KITTITAS COUNTY

DEPARTMENT OF PUBLIC WORKS

MEMORANDUM

TO: All Staff
FROM: Public Works Plan Review Team
DATE: August 4th, 2023
SUBJECT: Public Works Comments: VA-23-00004 Kosar Re-Notice of Application

31 Eagle View Dr
Parcel 902134
7-10-23

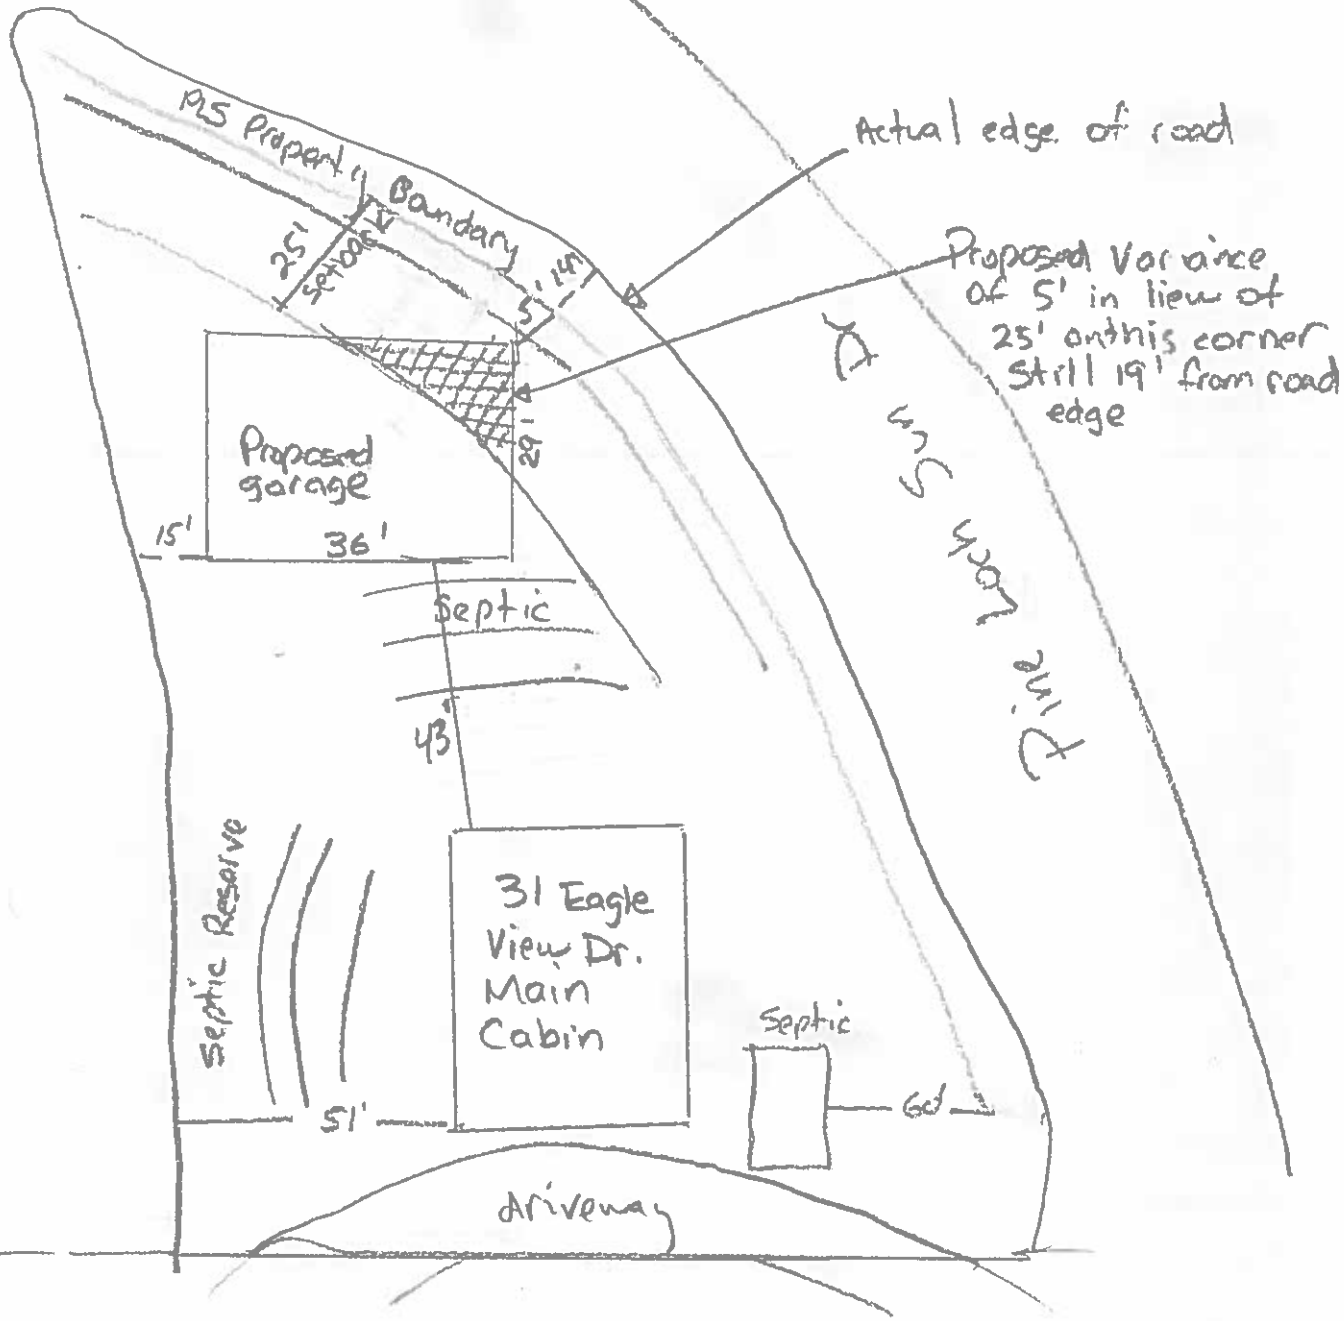
ACCESS	No Comments (TM)
ENGINEERING	<ol style="list-style-type: none">1. Previous comment was not addressed. Public Works is concerned that any excavation or fill required to build the garage may destabilize Pine Loch Sun Road. It is unclear from the Site Plan what the resulting slope will be. Please provide further information (proposed and existing) regarding the slope between the edge of road and the building pad. (CC)
SURVEY	<ol style="list-style-type: none">1. Site plan provided does not make sense. 51' and 60' offsets shown for a parcel that is only 100' feet deep.2. If approved, the building footprint and property boundaries shall be staked by a surveyor licensed within the state of Washington due to the tight tolerances proposed.3. If approved, no part of the building (foundation, swinging doors, roof eaves) shall fall within the reduced setback area.
TRANSPORTATION CONCURRENCY	No comments (KAH)
